Sea Link Energy Cable

**Natural England's Comments on Suffolk Landscape Visual Impact Assessment (LVIA)**

Planning Inspectorate Reference EN020026

9<sup>th</sup> January 2026

**Plate 3.2 Preferred area of acid grassland enhancement**

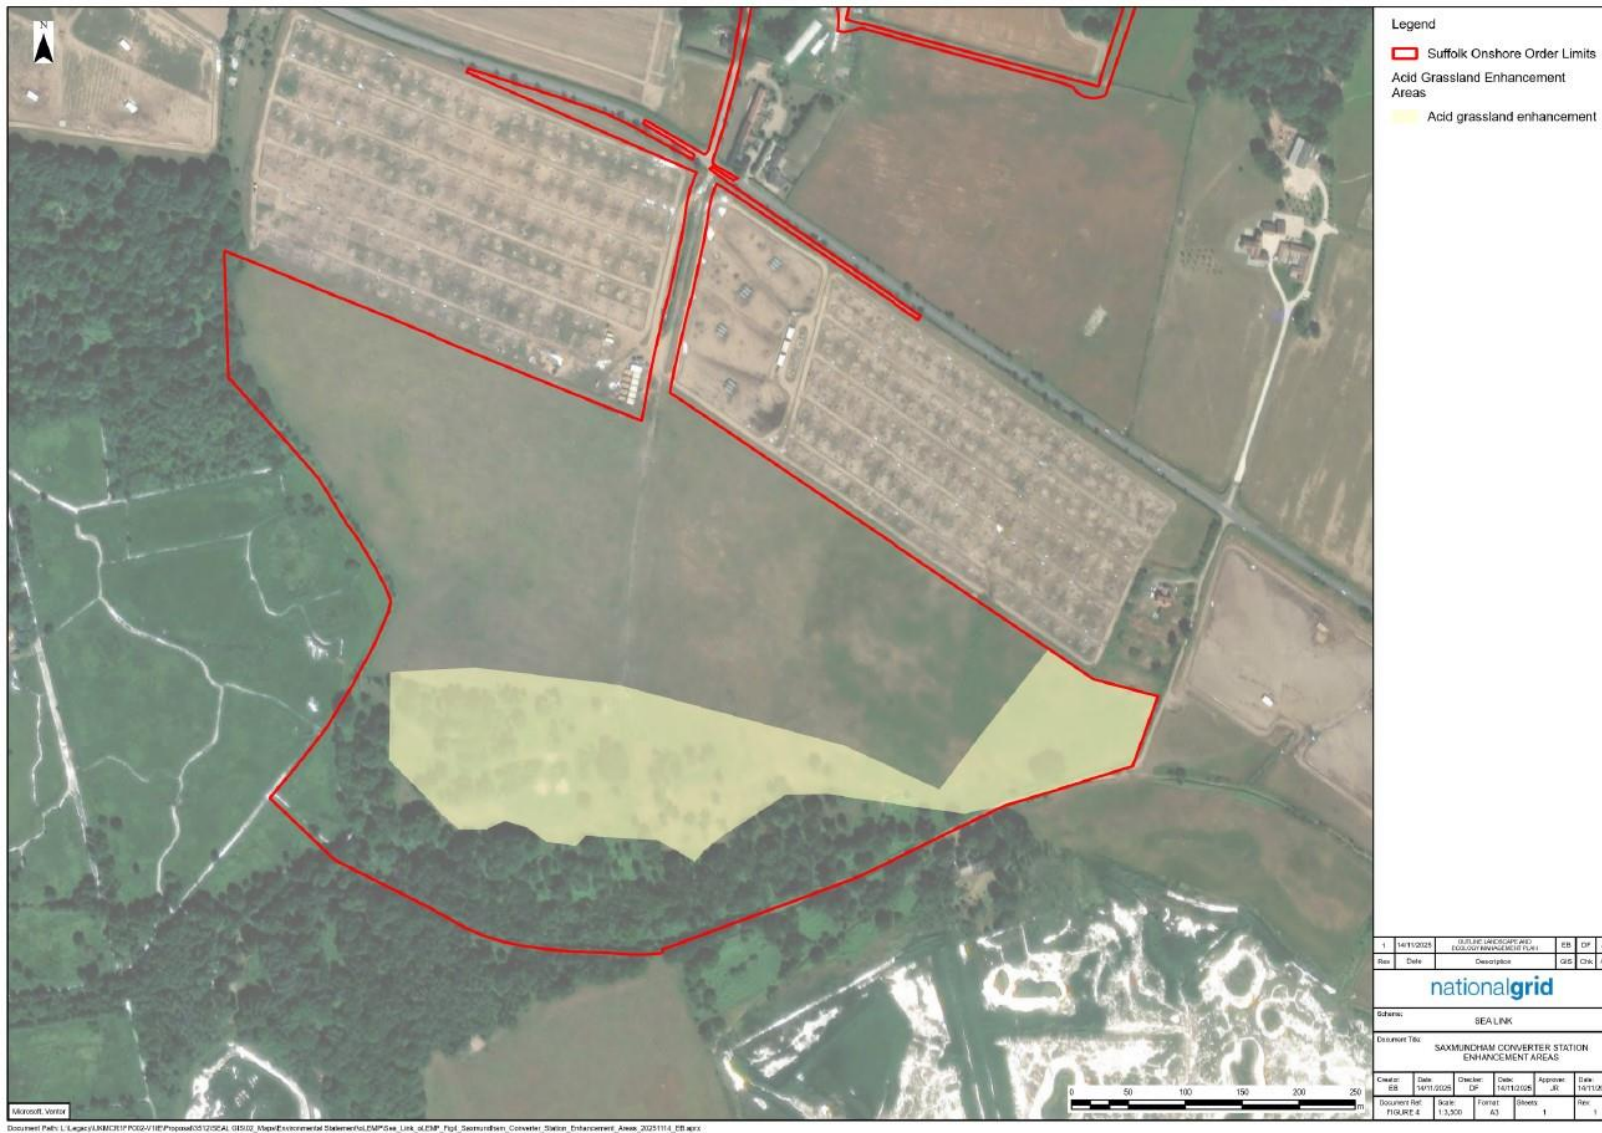
Document reviewed: [REP1-120] 9.47 National Landscape Section 85 Duty Technical Note				
NE Ref	Section	Key Concern and/or Update	Natural England's Advice to Resolve Issue	RAG
		<p>Whilst this is welcomed it remains unclear to Natural England what habitats are present in the identified 6Ha and how these will be enhanced. The area identified appears to contain deciduous woodland. How much acid grassland will be enhanced in this area?</p> <p>It remains unclear how the Applicant has considered impact pathways from the pig farm on the potential for reinstatement of the acid grassland. Please see our comments provided in Appendix titled 'Landscape and Visual Impacts including reference to documents included in REP1-120 regarding acid grassland proposals' at Deadline 2.</p> <p>It is unclear what the baseline pH is for this area and what impact inputs from the recently cultivated area adjacent to the 6Ha parcel may have on successful enhancements.</p> <p>We advise that an explanation of how 10 years is a sufficient length of time in which to manage this area to a sufficient standard to compensate for direct impacts to acid grassland in the Protected Landscape.</p> <p>We query why this area is not maintained for the lifetime of the project.</p>	<p>area implementation and management plan would be submitted into examination.</p>

Document reviewed: [REP1-120] 9.47 National Landscape Section 85 Duty Technical Note				
NE Ref	Section	Key Concern and/or Update	Natural England's Advice to Resolve Issue	RAG
		<p>The baseline, scope for enhancement and target condition are not detailed in the assessment material.</p> <p>For example, plates depicting target habitats in the Document 6.3.2.2.A Part 2 Suffolk Chapter 2 Appendix 2.2.A do not include this area.</p>		
5	Ex1.0.5 (cont'd)	<p>Natural England notes that the proposed acid grassland enhancement within the AONB has multifunctional purposes to further the purpose of the AONB, notably including landscape, ecology and Biodiversity Net Gain.</p> <p>As above we consider avoidance of impact to be key here.</p> <p>The report clarifies that the 6 Ha proposed enhancement area is less than the area impacted by the scheme.</p> <p>It is not clear how this area achieves multifunctional purposes. This appears to be conflated. Clarification is therefore required regarding the targeted function of the 6ha land.</p> <p>It appears that this 6Ha area would form part of compensation for direct impacts to acid grassland. However it is not connected to the area of impact and appears to already contain habitats of biodiversity interest.</p> <p>Furthermore, mitigation, compensation and enhancement need to be considered with Biodiversity Net Gain considered after this.</p>	<p>We advise that the assessment of impact must have clear auditing of baseline (including the 6Ha area), measures to avoid impact (in line with the mitigation hierarchy), mitigation to reduce impact and where impacts are unavoidable, compensation</p> <p>And this should be used to determine the targeted function of the 6ha of land ensuring that it is fit for purpose.</p>
